# Rezoning Transportation Analysis

Petition Number: 2022-146

## Revision Log:

Date	Description
1-25-23	First Review (IW)
04-19-23	Second Review (IW)
06-21-23	Third Review (DR)
07-27-23	Fourth Review (IW)
08-29-23	Fifth Review (TM)

<p>Issue Date: 12-21-22</p> <p>Project Number: 199.005</p> <p>Sheet 1 of 1</p>	No.	Date	Description	1	3-10-23		2	1-10-23				
No.	Date	Description										
1	3-10-23											
2	1-10-23

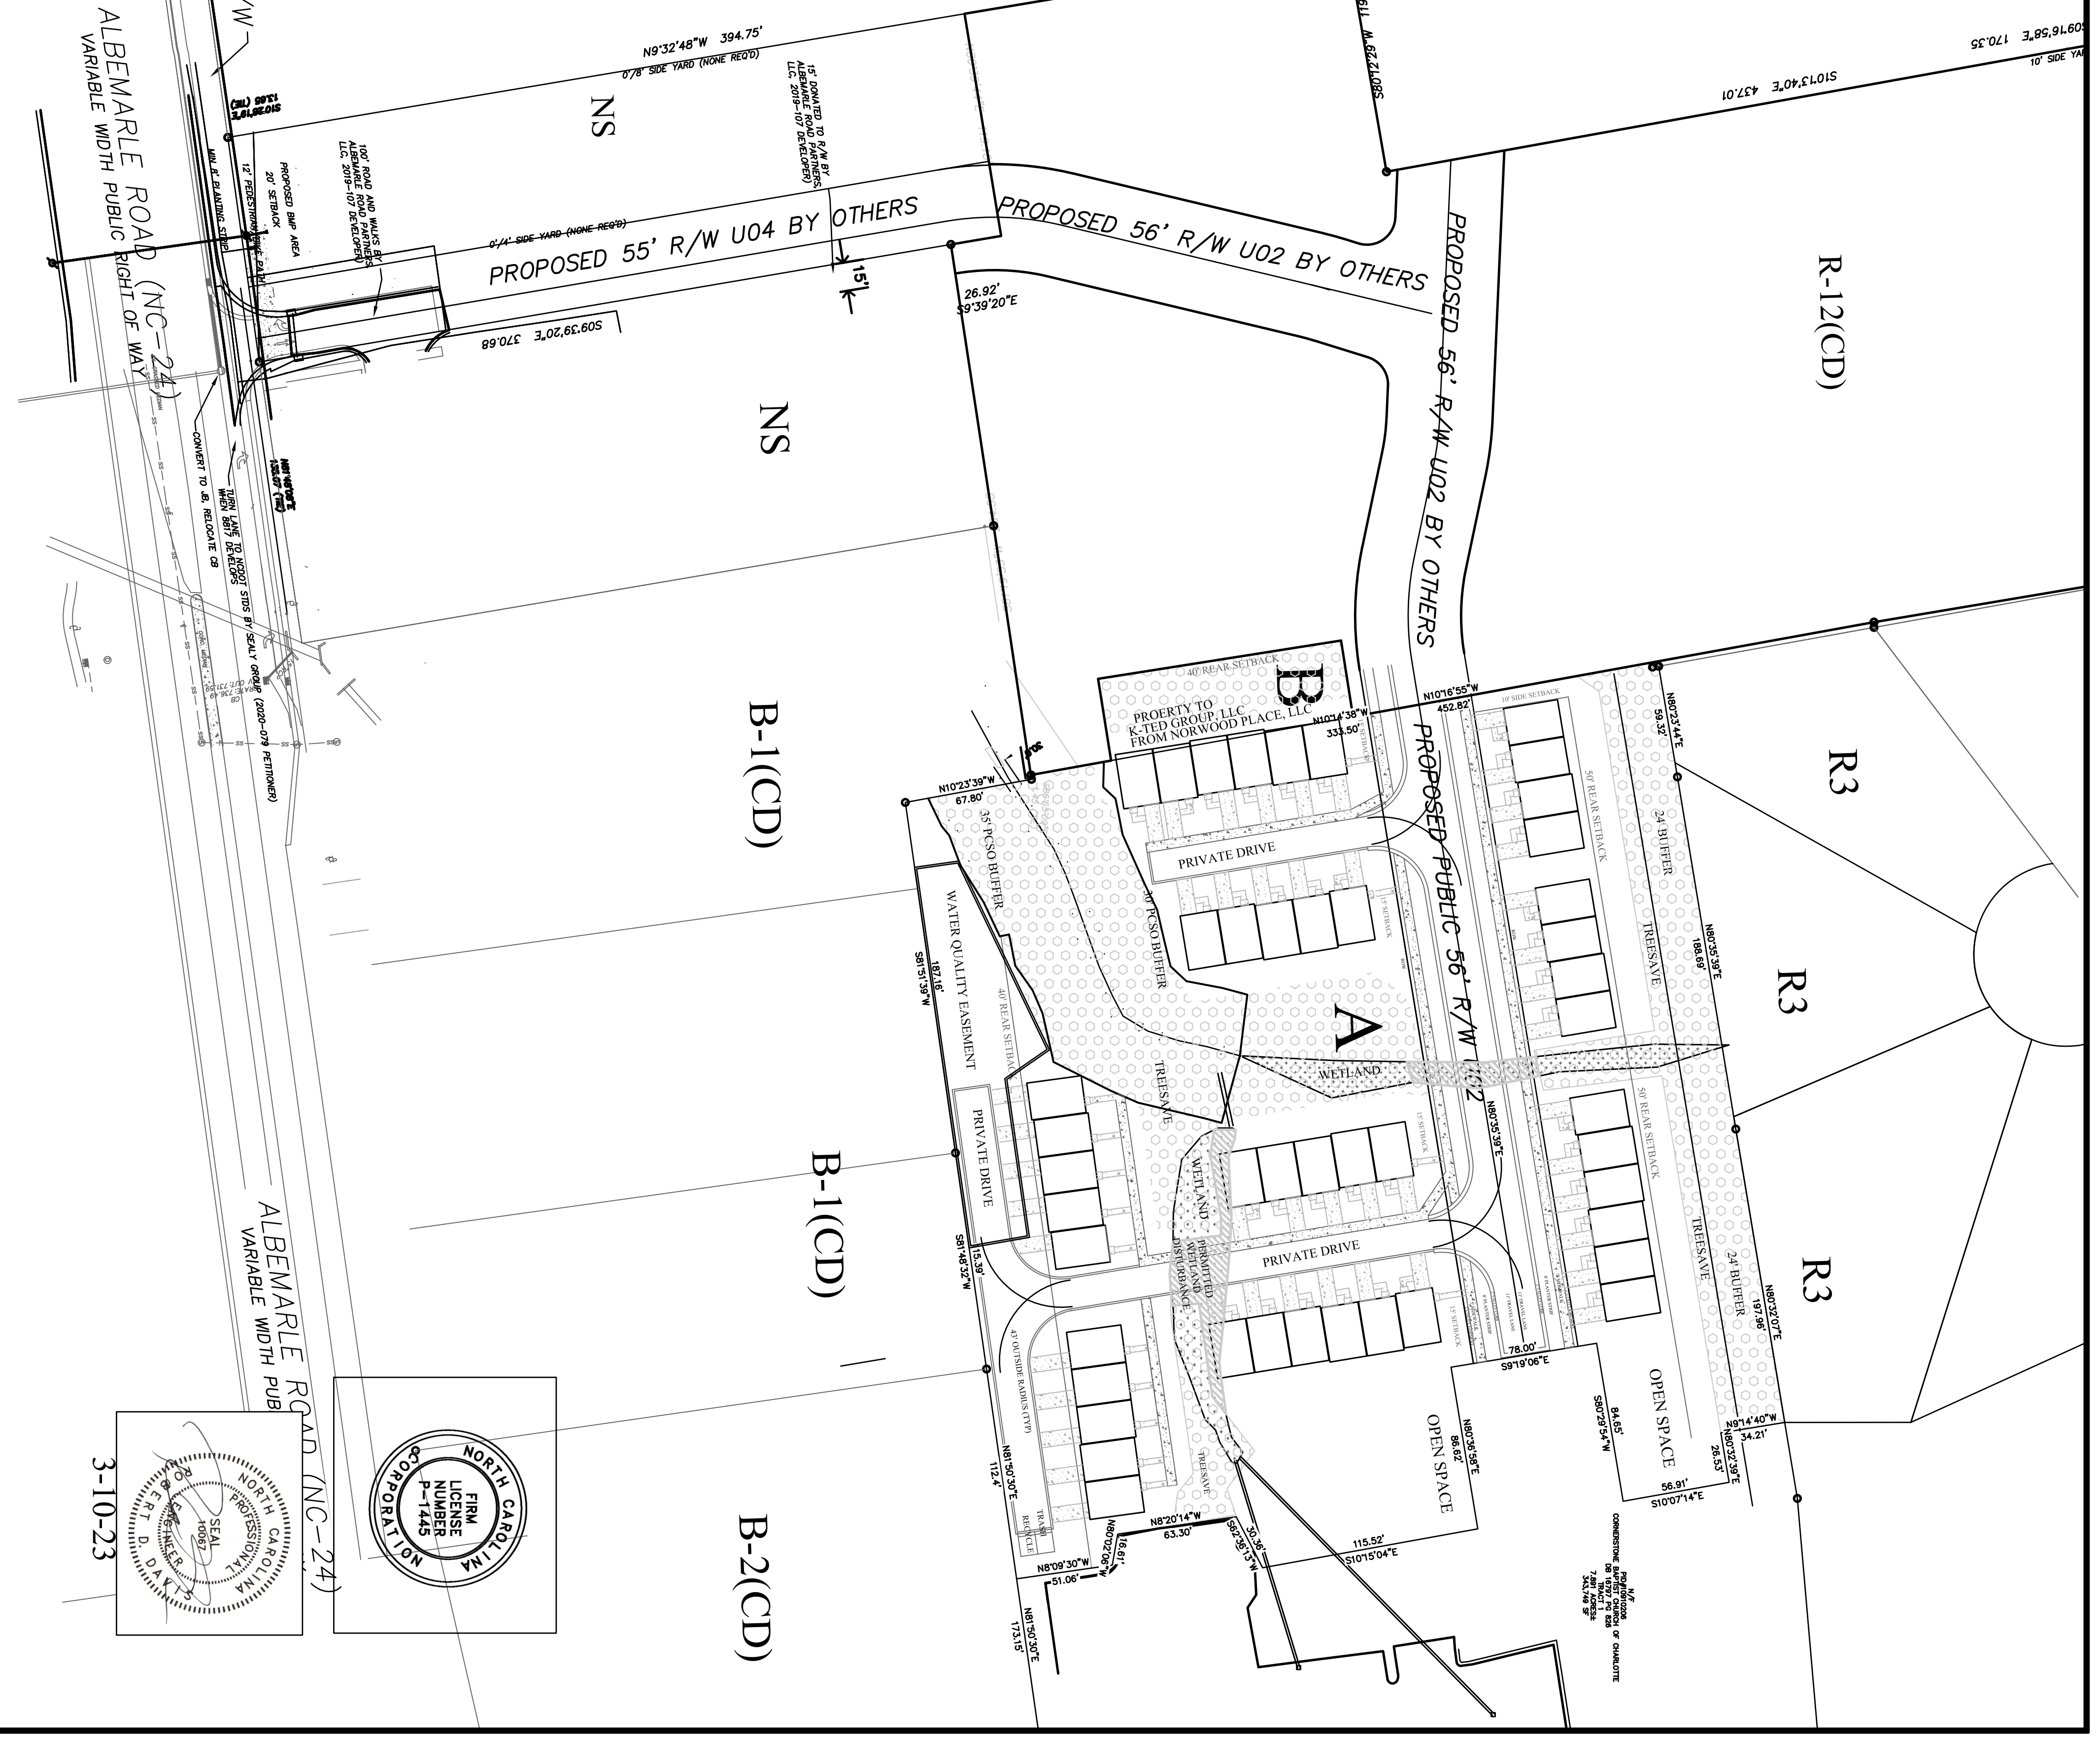
- 3. ~~Revise site plan and conditional note(s) to commit to construct an 8-foot planting strip, and 5-foot sidewalk on Dusinane Extension per Chapter 20. The site plan shall label and dimension both items from the back of curb and gutter or edge of pavement.~~

**Clarifying Comment 4-20-23:** Update conditional notes to commit to constructing Dusinane as a U-02 and constructing the 8 foot planting strip and 5 foot sidewalk.

- 4. ~~Revise site plan to remove public right of way designation for private streets as shown below. Label and provide CLDSM designation for proposed private streets.~~
